From: Sarah Burrow <Sarah.Burrow@arun.gov.uk>
Sent: 20 October 2021 14:33
To: Planning.Responses <Planning.Responses@arun.gov.uk>
Cc: Amy Myer <Amy.Myer@arun.gov.uk>
Subject: RE: Planning Consultation on: BN/126/21/DOC

Engineers Comments Regarding Surface Water Drainage

Application No: BN/126/21/DOC

Site Address: Tile Barn Farm 32 Hill Lane Barnham PO22 0BL

G6445-02

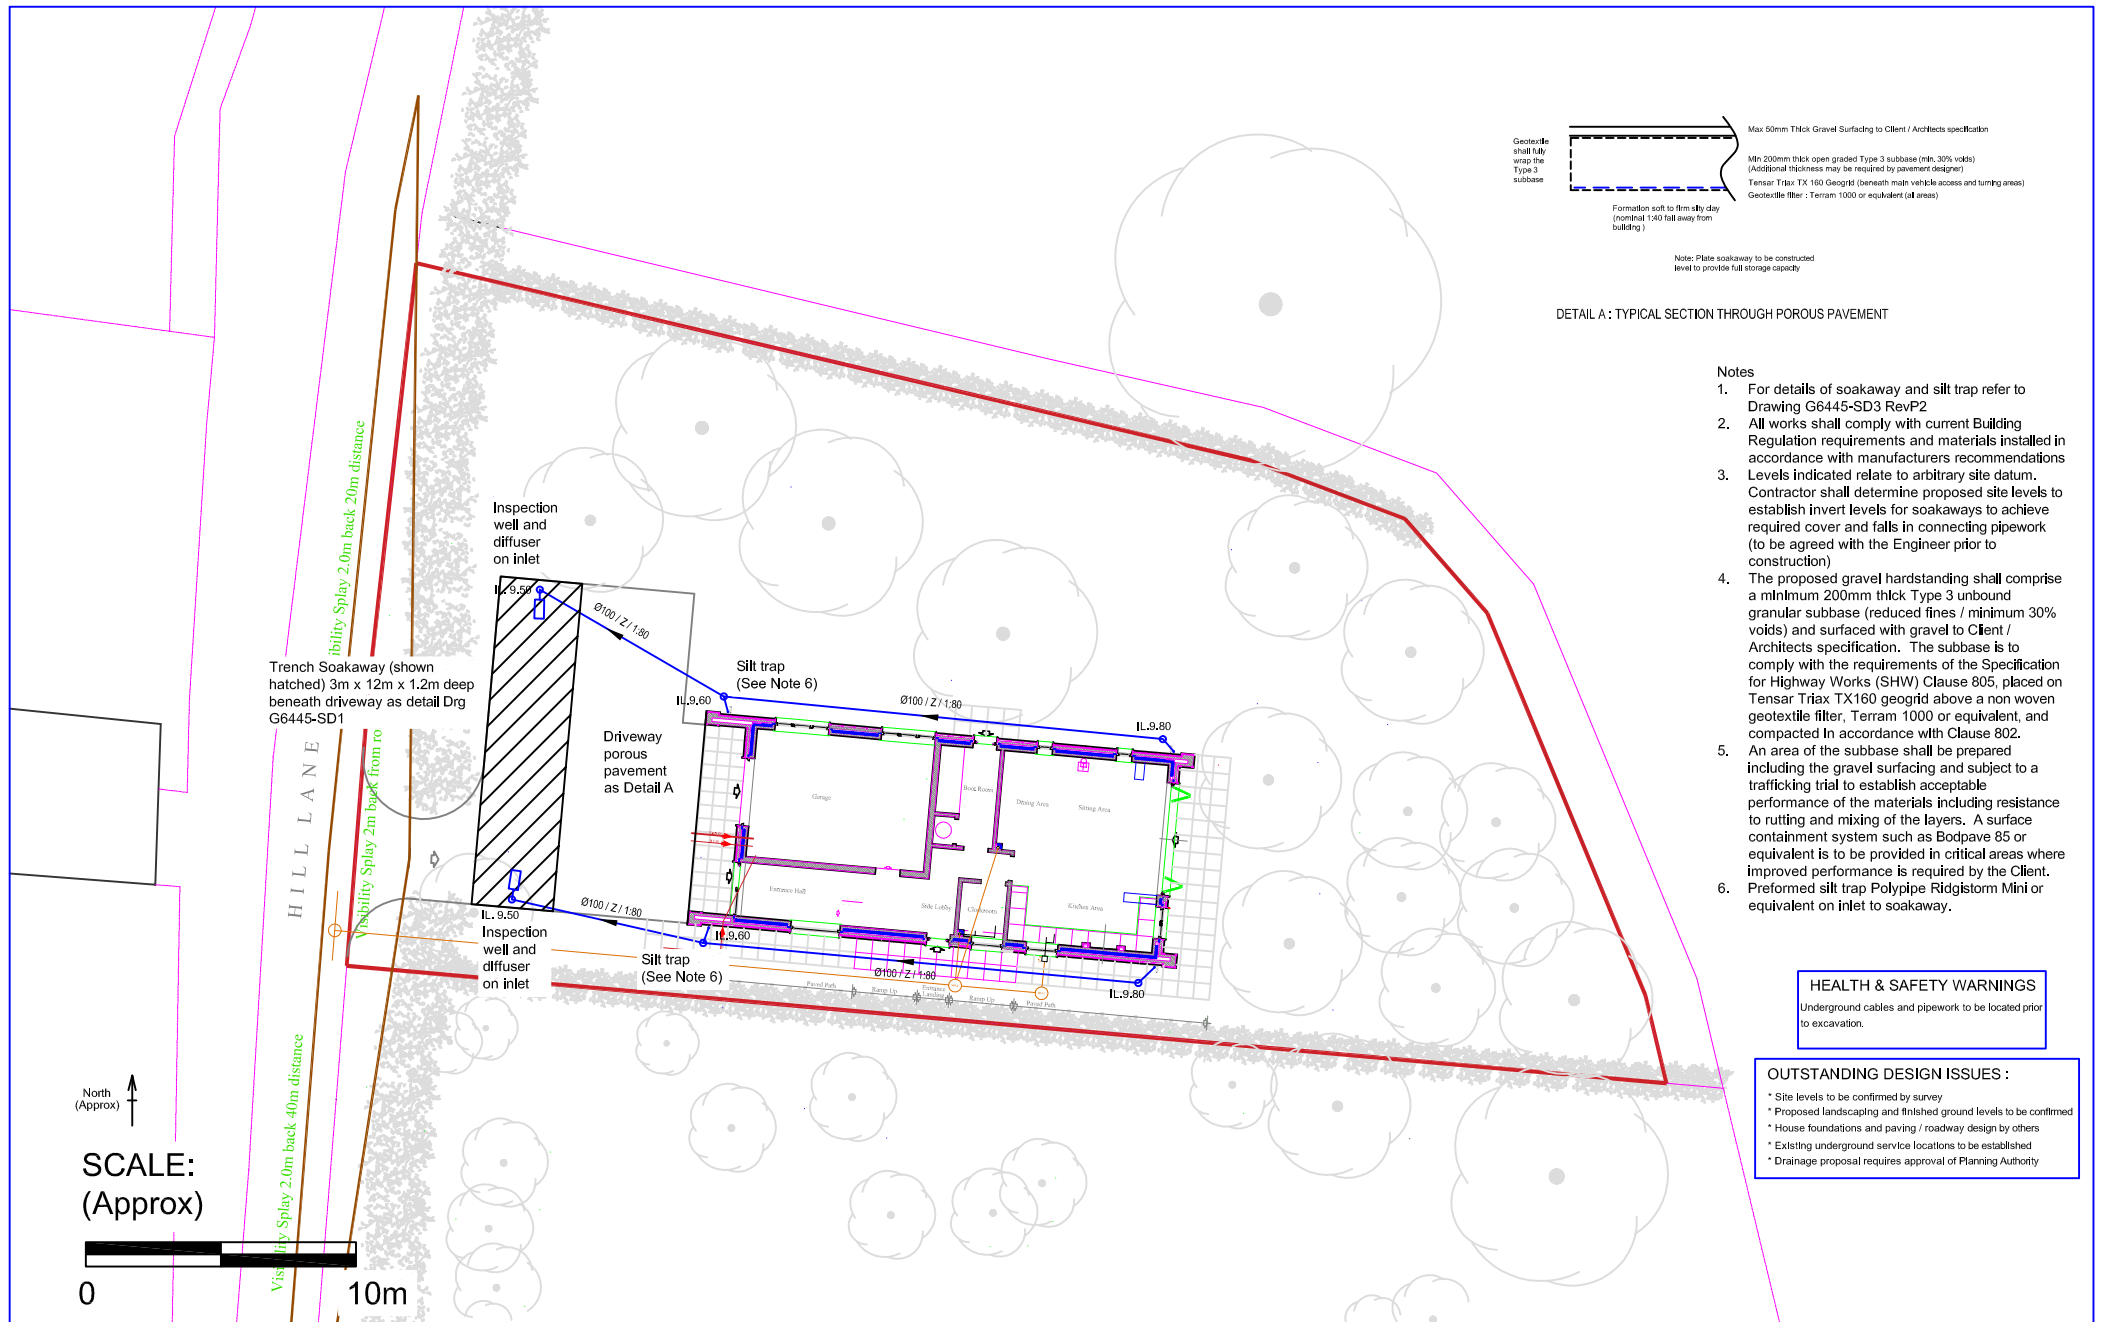
The drainage layout shows preformed silt traps (Polypipe Ridgistorm Mini or equivalent), and yet the catchpit detail shows an alternative to a pre-formed silt trap. Please show the pre-formed silt trap on the construction detail or change Note 6 to be a bespoke silt trap as shown on the construction details. Please also include sump depths, cover types and cover levels on the drainage layout.

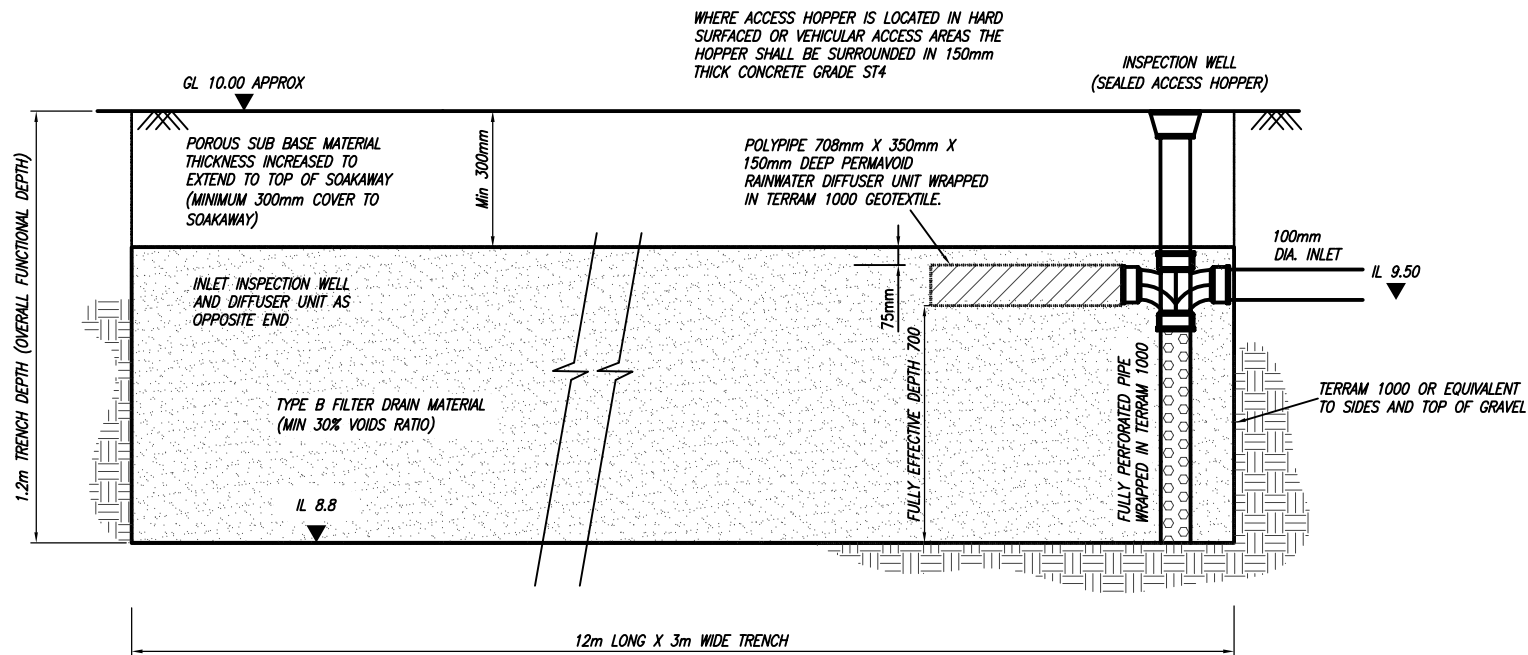
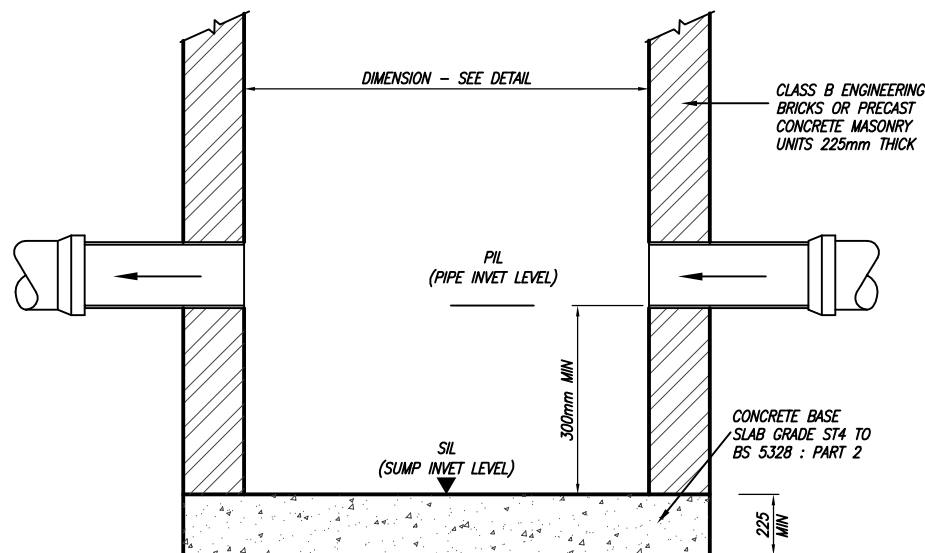
The calculations that have been provided illustrate only the invert level of the soakaway (8.8m) and the ground (cover) level (10m). I am concerned that they assume the depth of the soakaway to be 1.2m rather than the effective depth of 0.7m. Please can the applicant clarify these inputs so that I can be sure that the soakaway drawn is what is modelled.

Please specify no fines in the granular fill of the soakaway.
